A38 Derby Junctions
TR010022
8.15 Statement of Common Ground with
McDonald's

Statement of Common Ground
McDonald's

Version	Date	Status of Version
Draft	10 February 2020	Deadline 5 Submission

RETAINED ACCESS WITH A38 WORKS

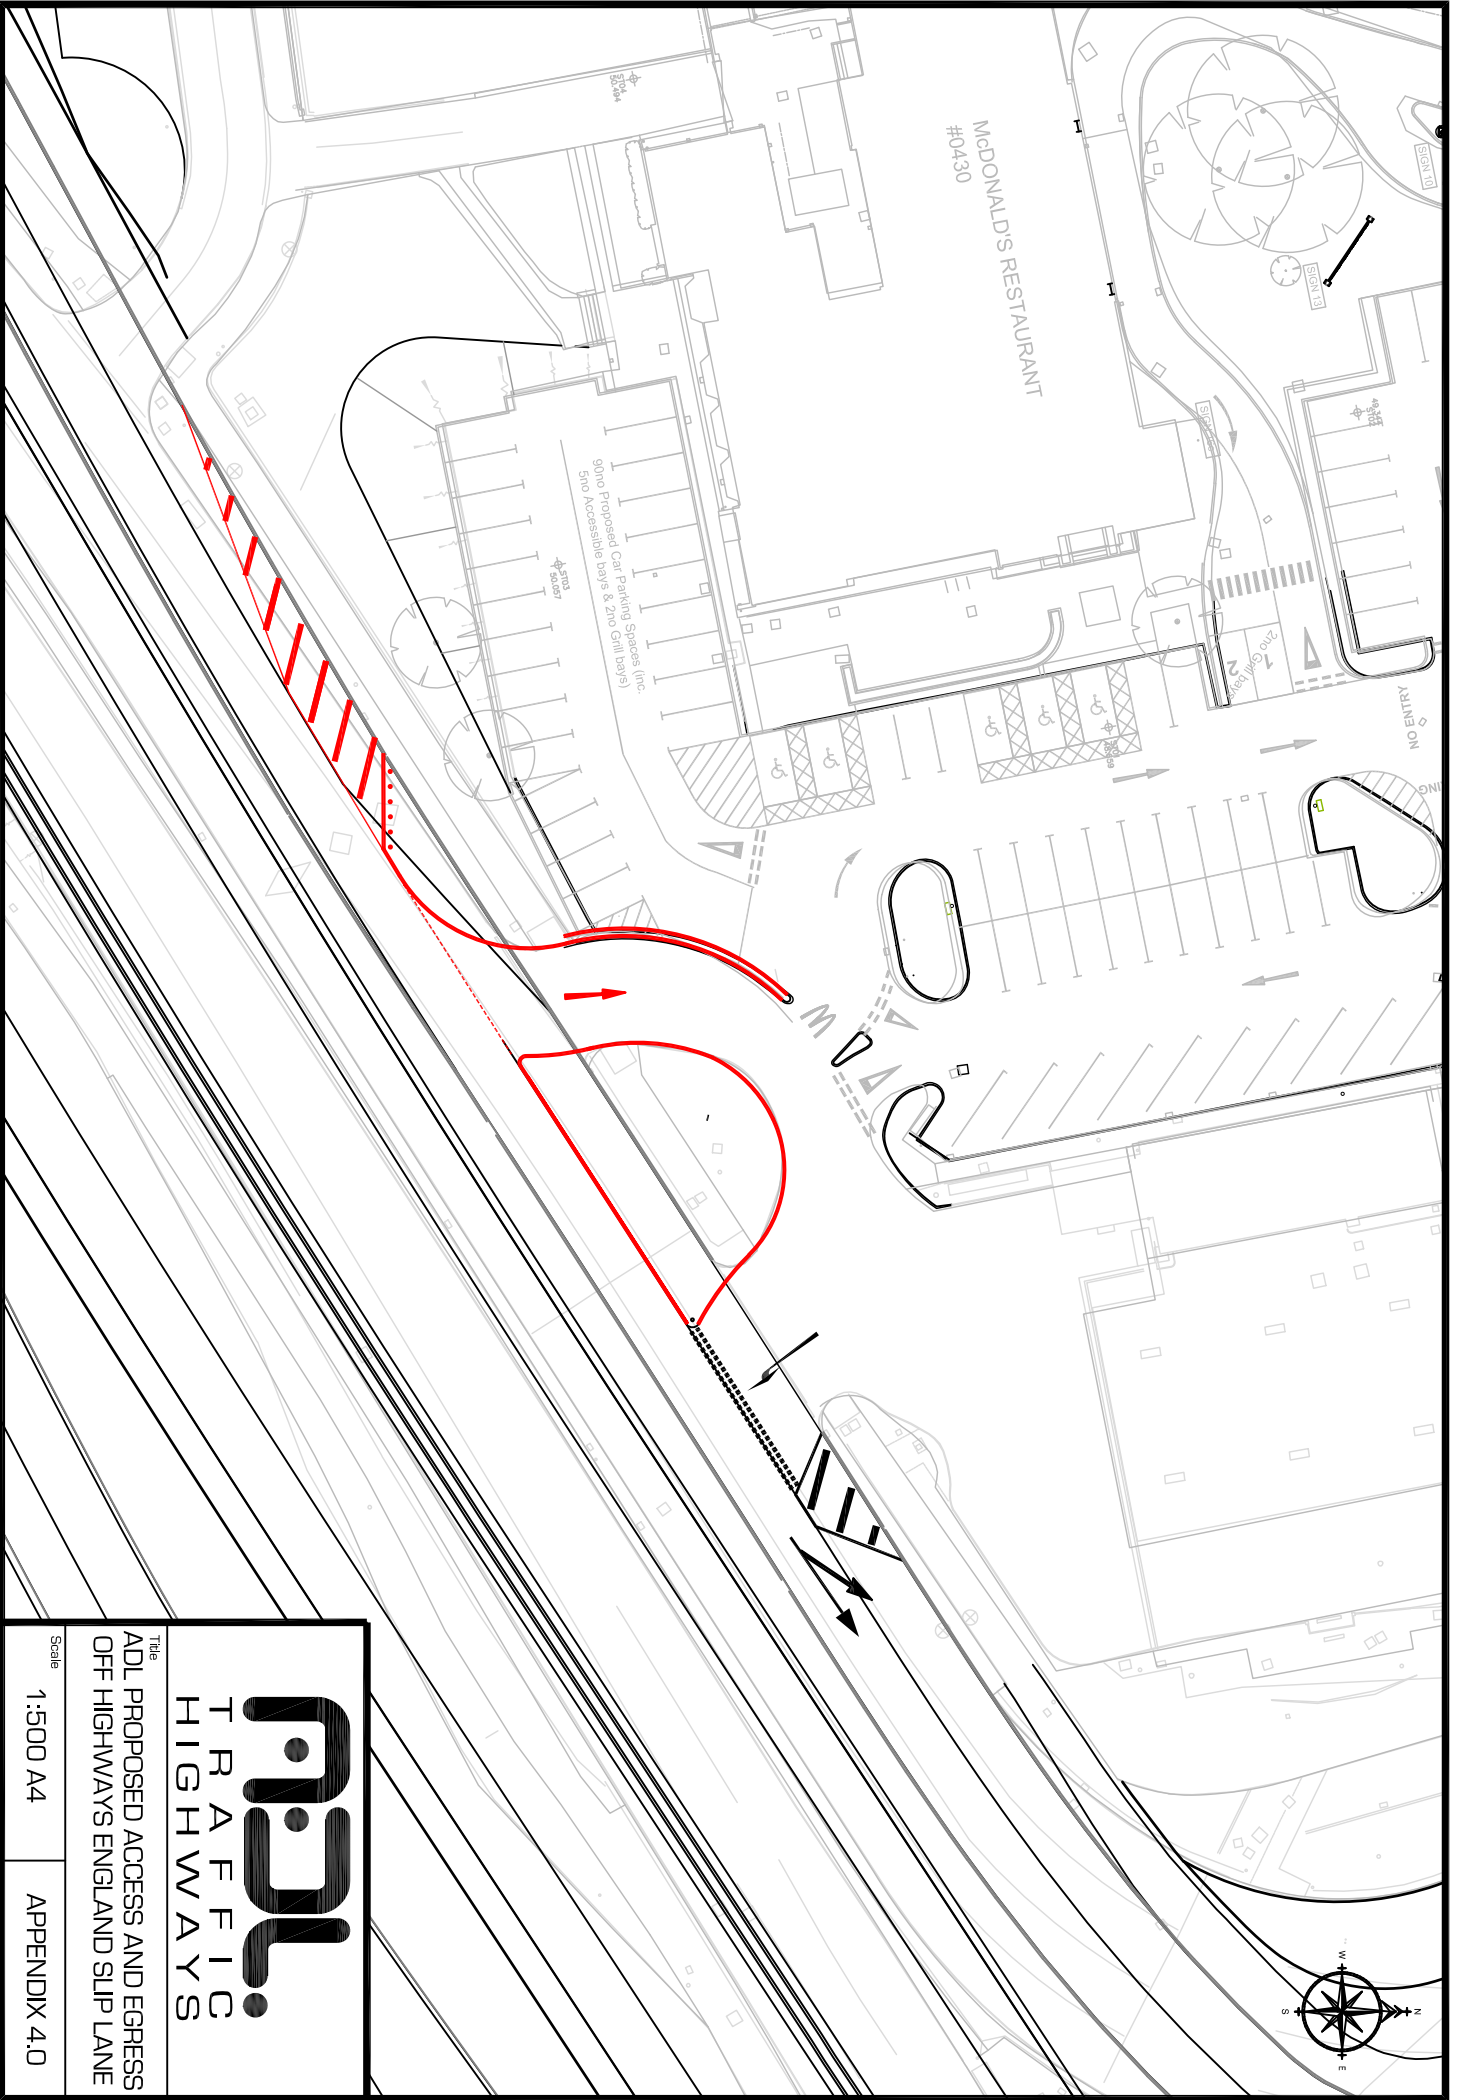
Issues Reference (see Appendix A)	Document	Paragraph Ref	Sub-section	Comment	Highways England Response	Status
Issues ref: I.1, access and economic impact	Written Representation Comments*	Point 1	a)	The Works involve closing the entrance to the Property from the A38. This would cause increased queuing at the Ashbourne Road entrance and exit to the Property, posing a health and safety risk to road users, as well as negatively impacting McDonald's business, brand, sales, operations and the amenity of the local area for residents (in each case during and after the works). Additionally, the increased capacity at the Ashbourne Road junction will go beyond its capability.	Exiting the site onto the A38 will continue to be an option after implementation of the scheme. Entry to the site from the A52 will be via a new signal-controlled junction so will not cause queuing within the site.	Not agreed
Issue ref: I.1, access and safety	Written Representation Comments*	Point 1	b)	The proposed installation of traffic lights at the Ashbourne Road junction will cause gridlock and queuing inside the McDonald's site, especially around the access and egress to the Drive-Thru lanes.	The proposed exit on the A52 should be able to perform better than the existing exit due to the introduction of traffic signals At meeting of 15 th Jan 2020, McDonald's agreed to to assess capacity by carrying out their own LINSIG analysis of the junction – results to follow	Under discussion
